THE HILLS SHIRE COUNCIL

8 December 2025

Our Ref: 43/2025/PRE
Your Ref: SSD-96248991

Rouse Hill Hospital

Drawn : SZ  
 Designed : -  
 Project No. : H357  
 Bar Scale

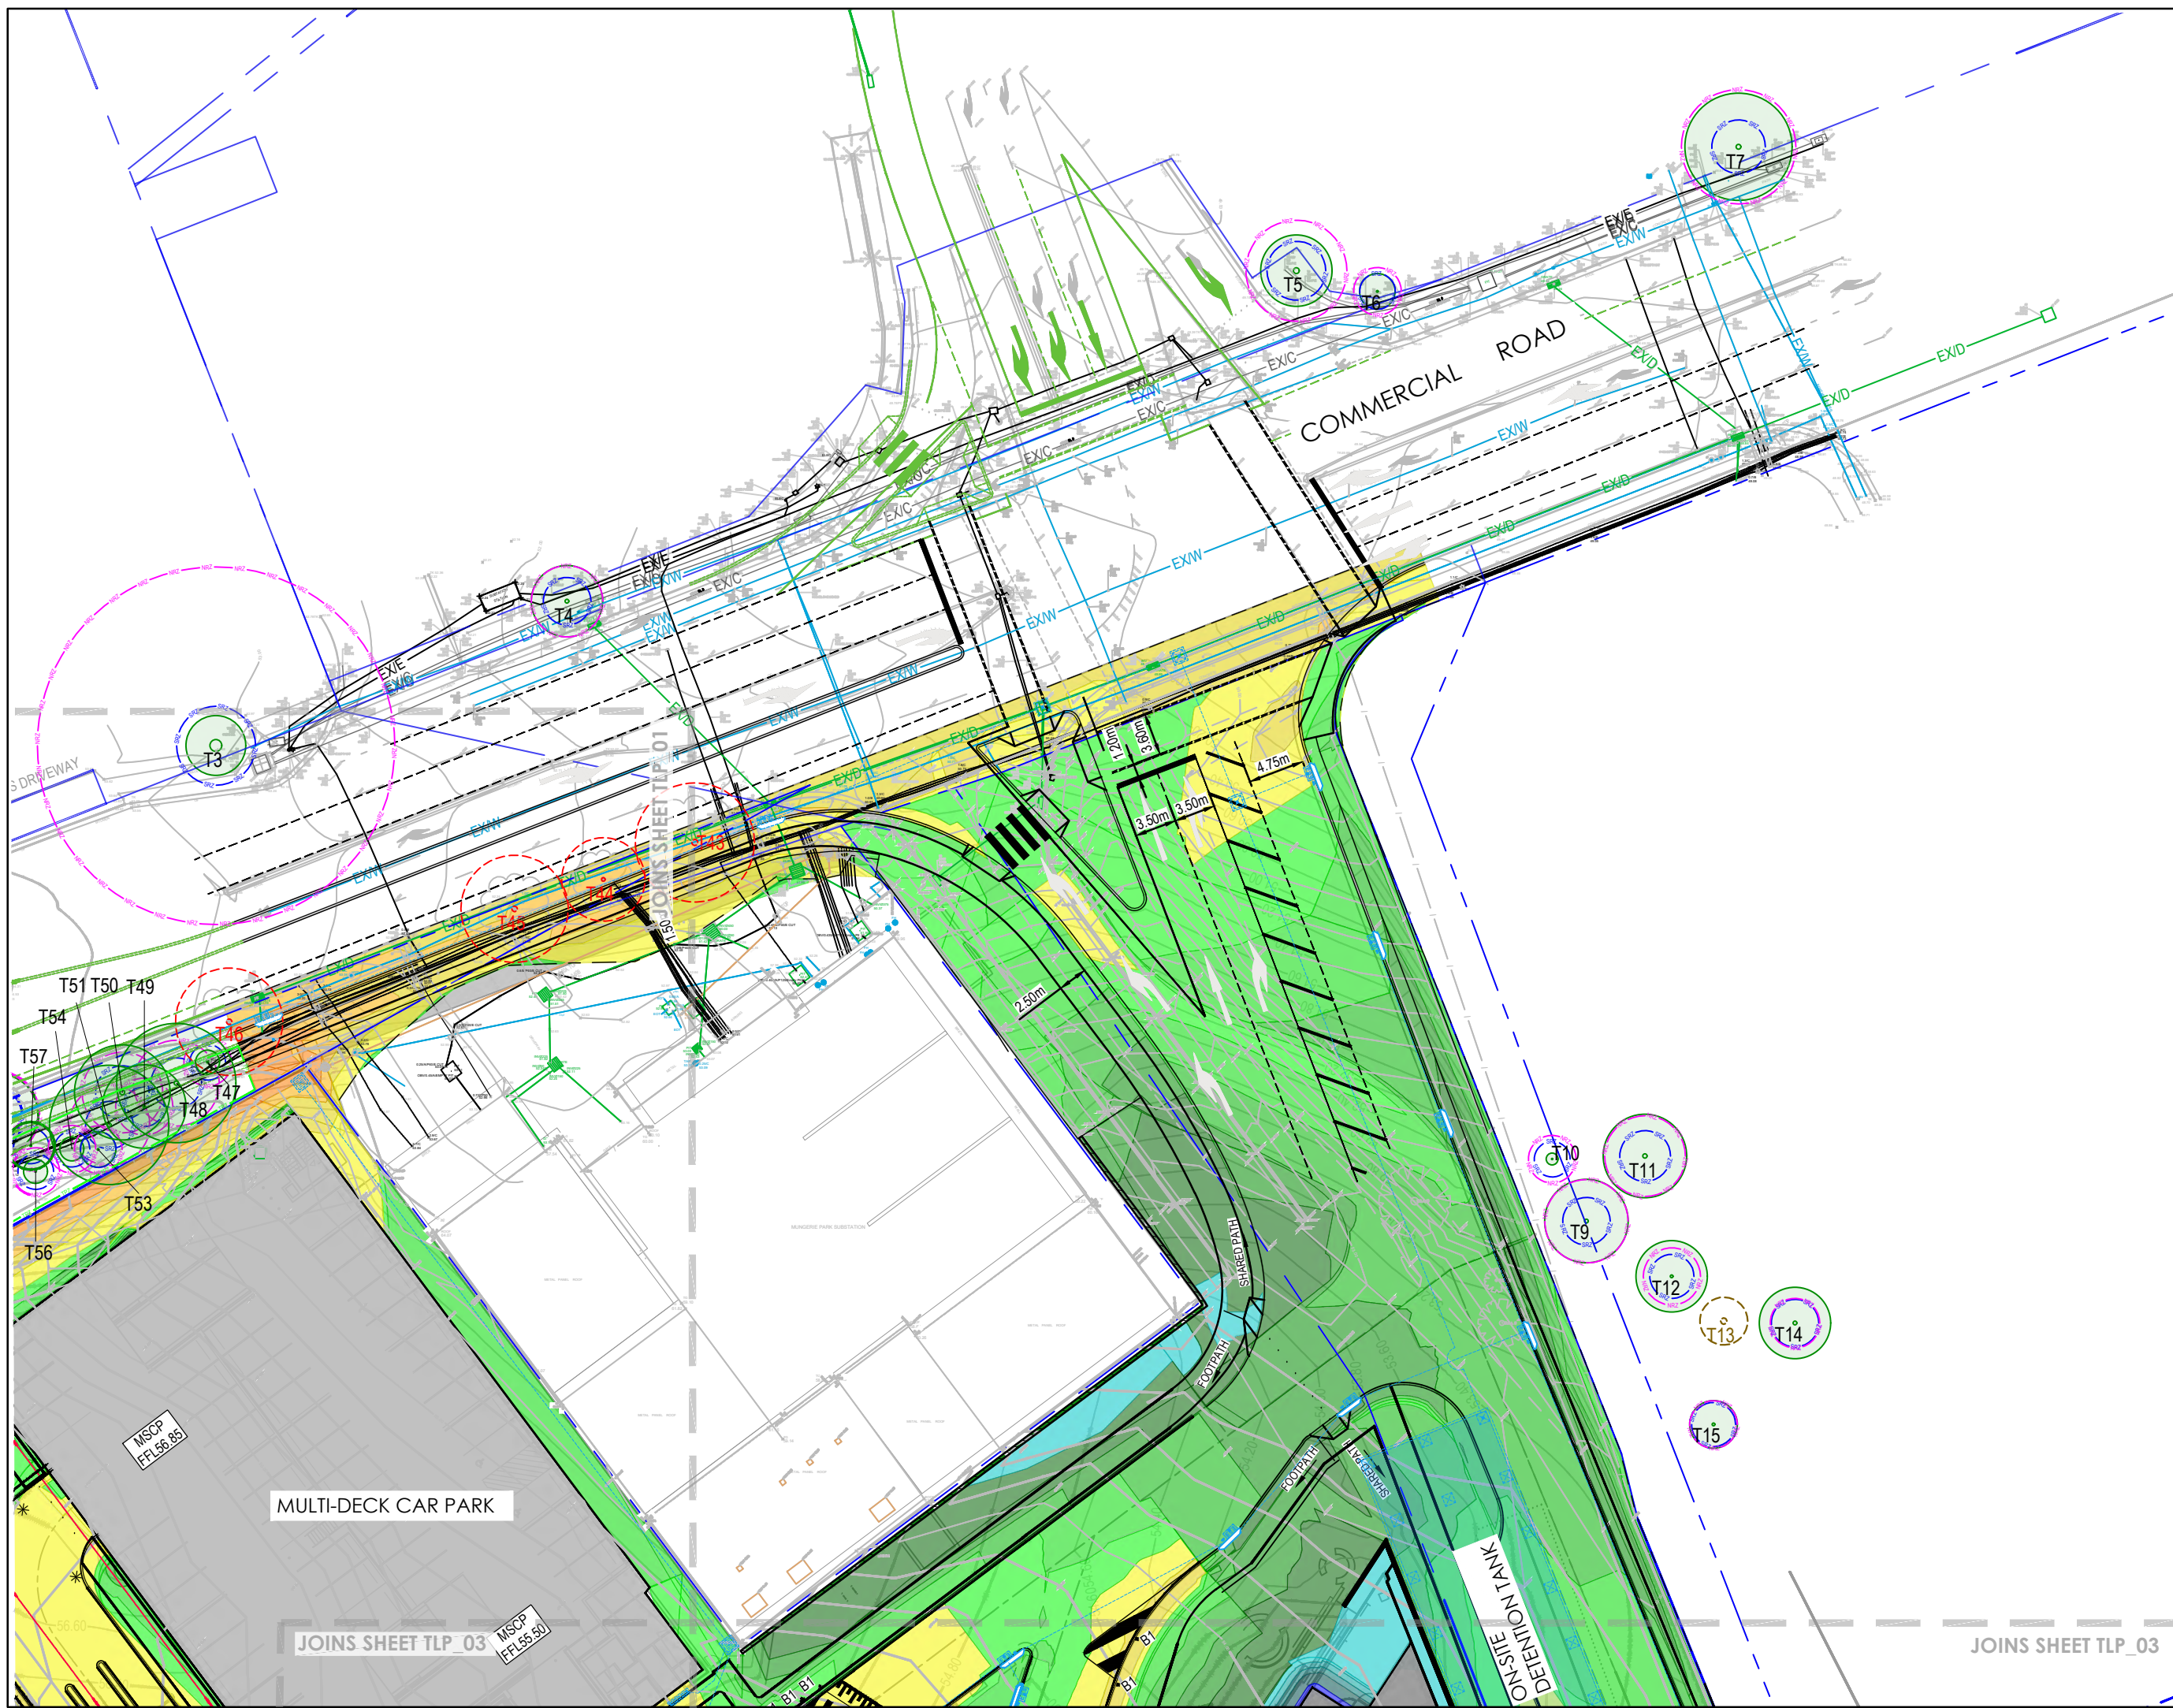
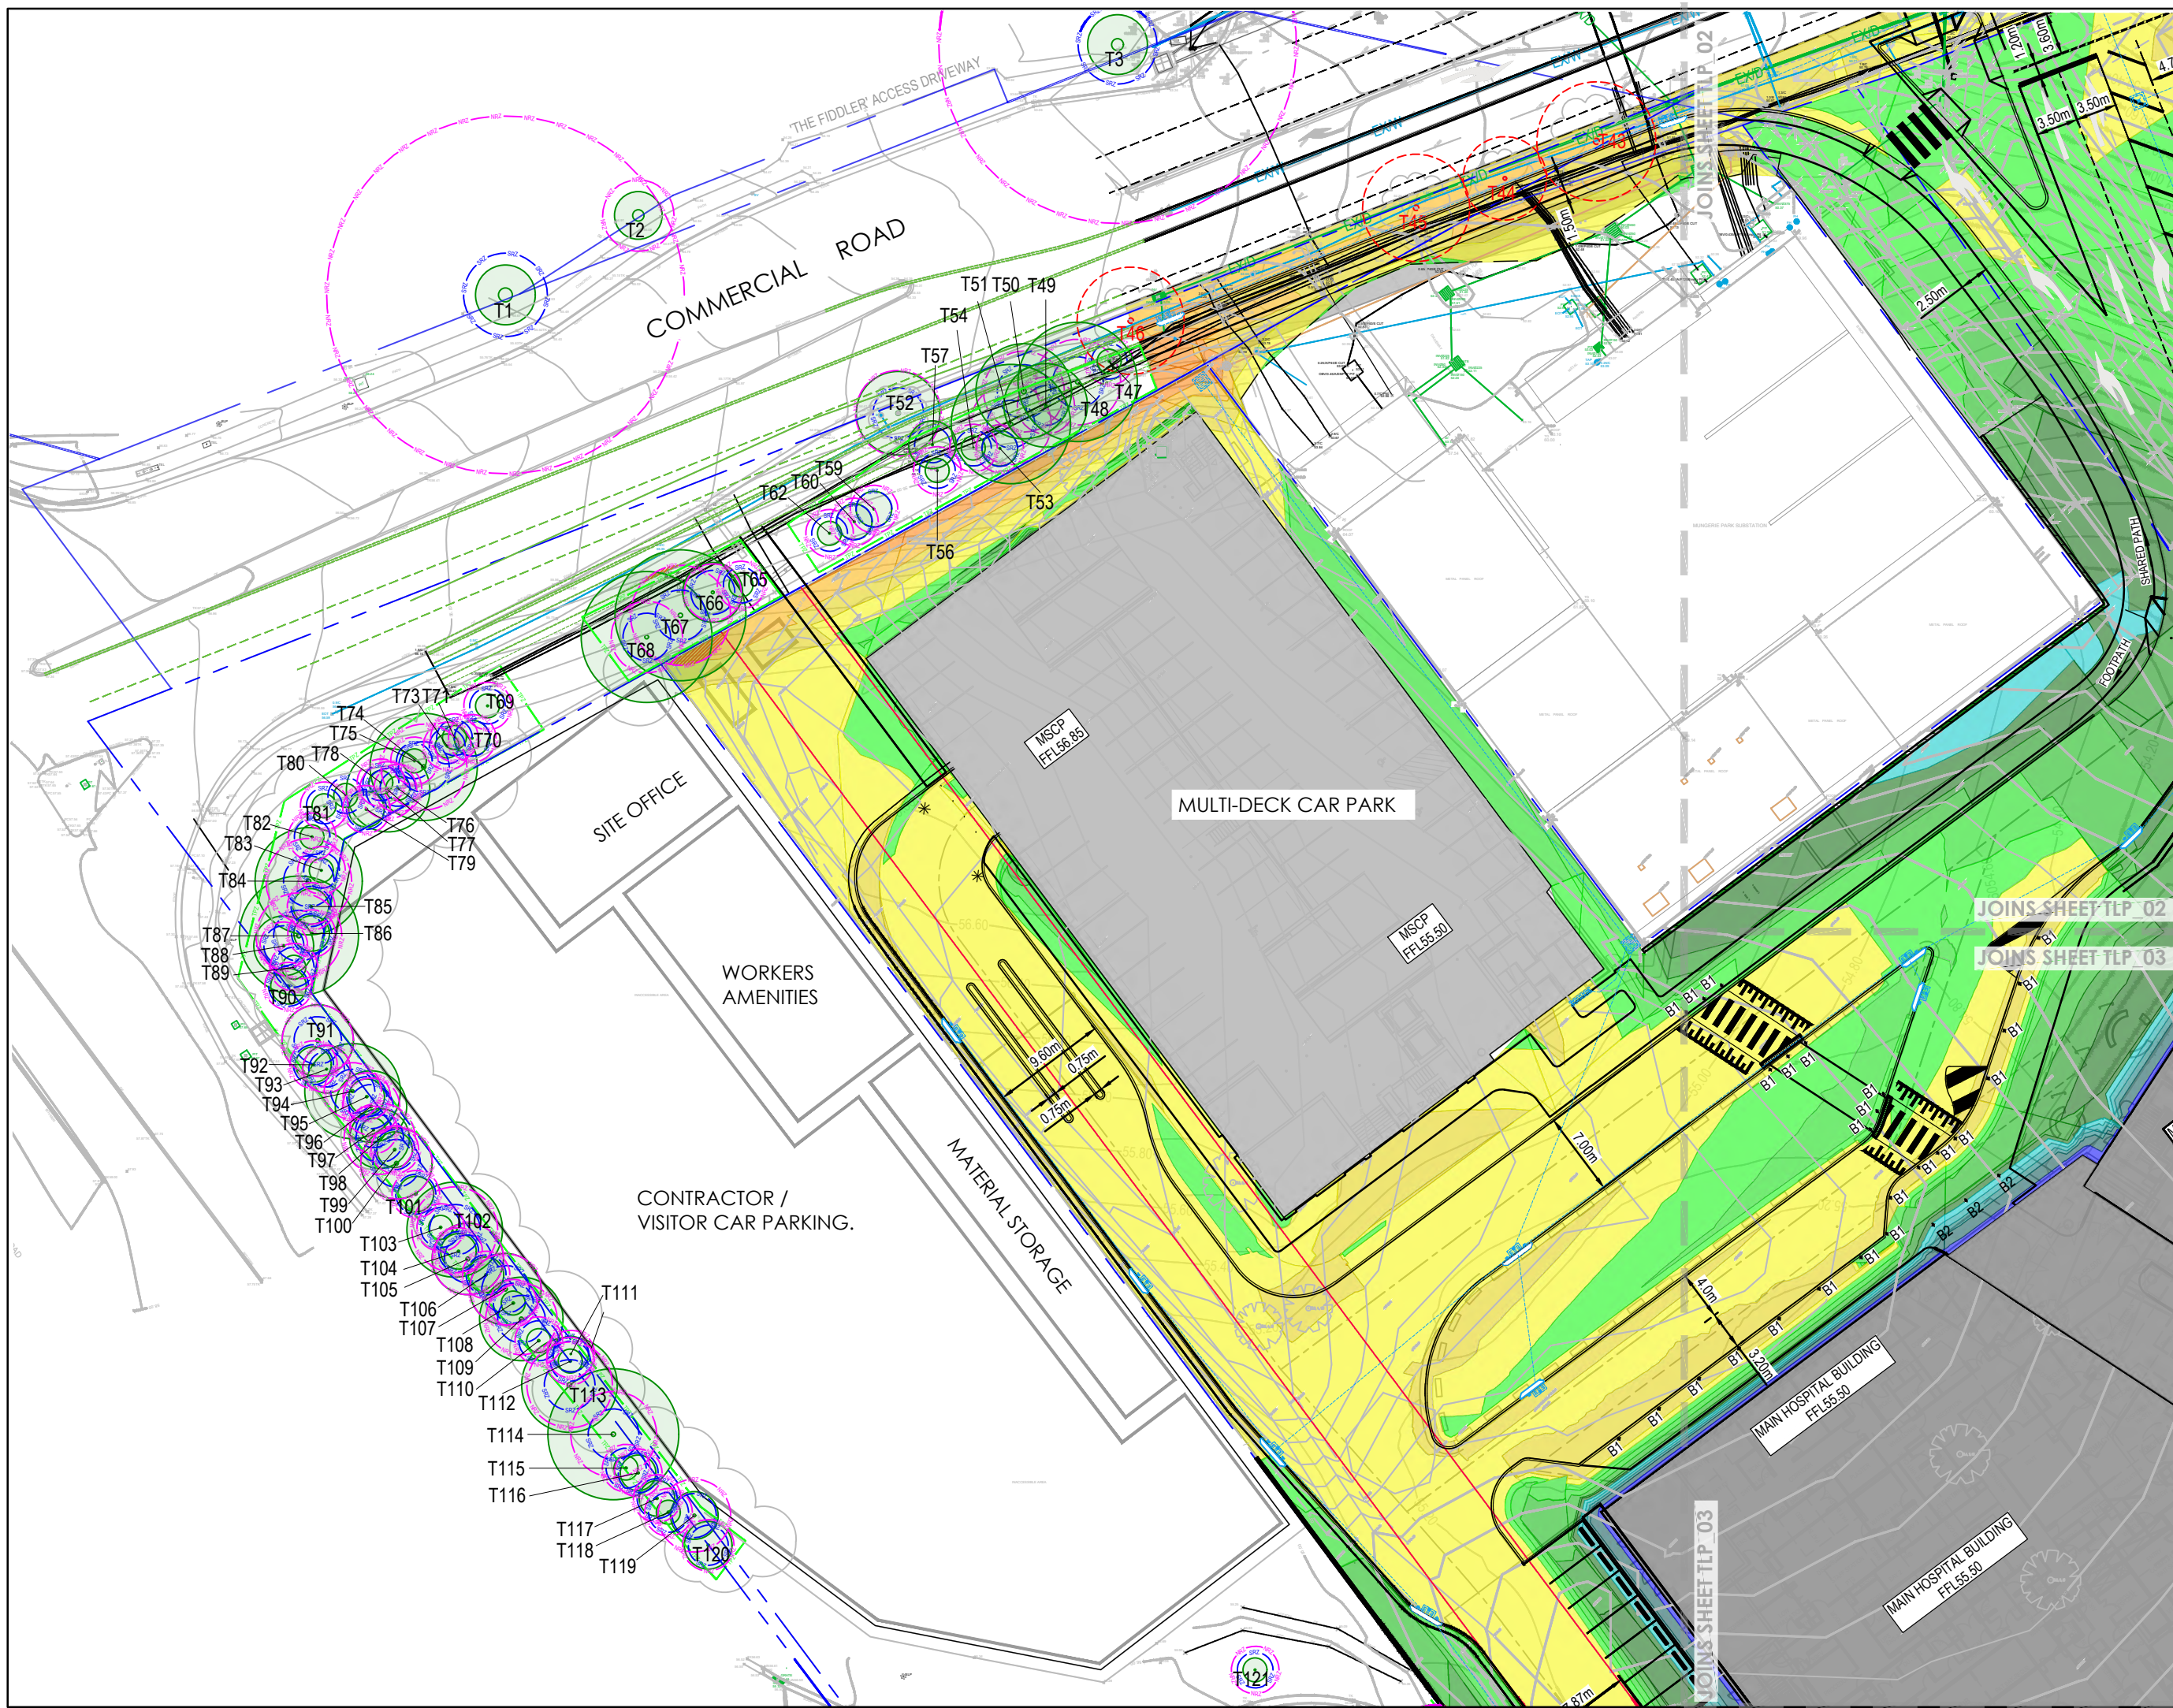
- a. Trees 43–46, identified as *Corymbia maculata*, are of high retention value and currently function as street trees along Commercial Road. Removal of these trees may be justified with measures implemented to replace them through the proposed landscape design. Replacement planting must achieve equivalent canopy contribution and comply with relevant council and AS 4970:2025 – *Protection of Trees on Development Sites* requirements.
